Planning Reg No: EXD00927

Proposed: Shed of 19.9 sqm internal floor area to rear of house

Location: Doogan's Warren, Rosslare Strand, Co. Wexford, Y35HY00

Application for Declaration of Exempted Development
(Part 1, Section 5)

C-115

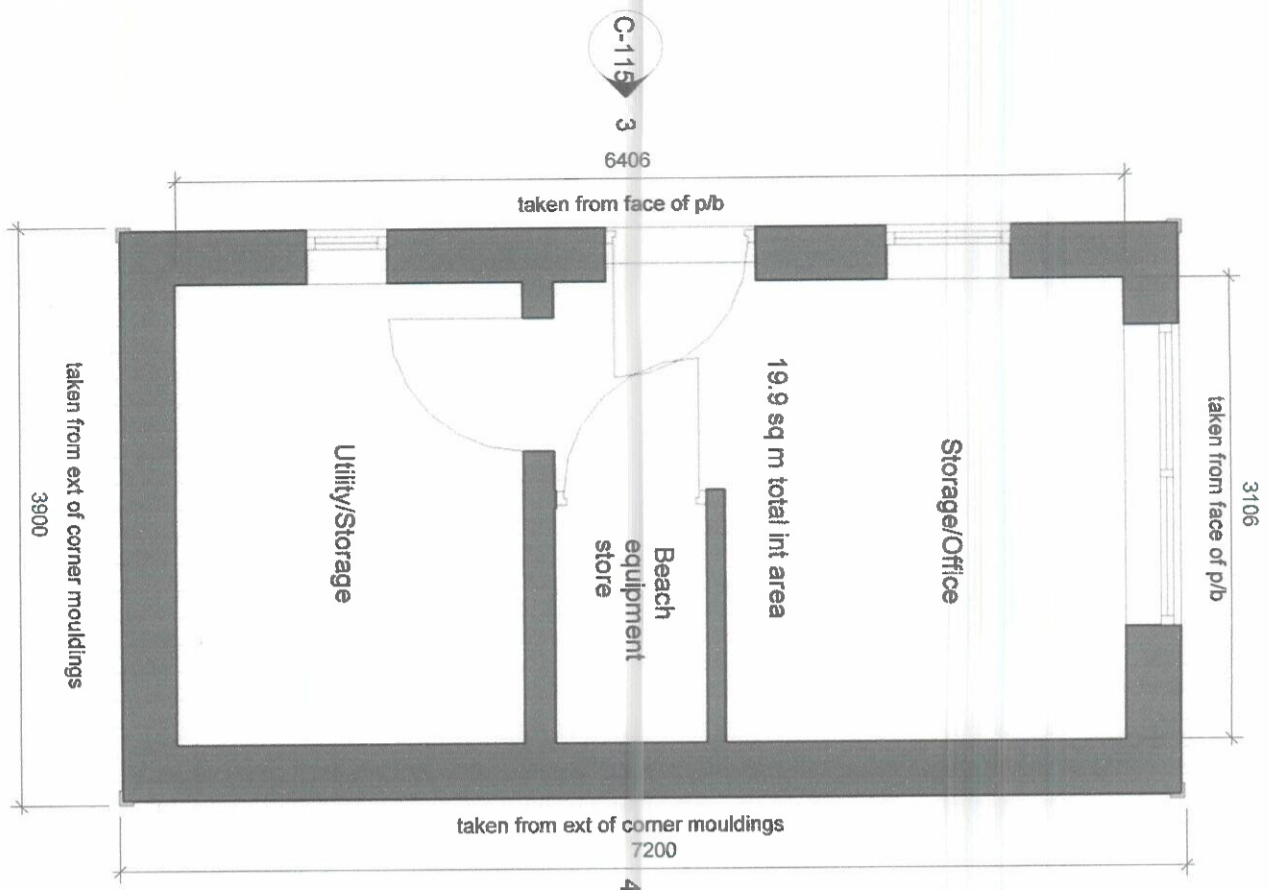
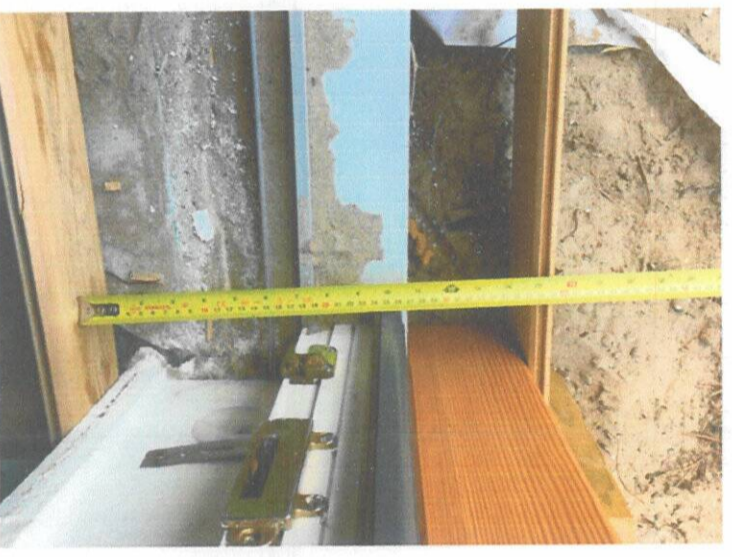
From measurements carried out by technical staff of Wexford County Council (on the 18/08/2021) site the internal floor area of the structure (i.e. 6.4m x 3.1m) is calculated as 19.84sqm. The external dimensions (i.e. 7.2m x 6.4m) is calculated as 28.08sqm. The total area therefore exceeds 25 square meters.

I consider, therefore, that the floor area shed exceeds the allowance of 25sqm and thus cannot avail of the exemption as set out in Class 3 of Part 1 of Schedule 2 of the Regulations. ✓
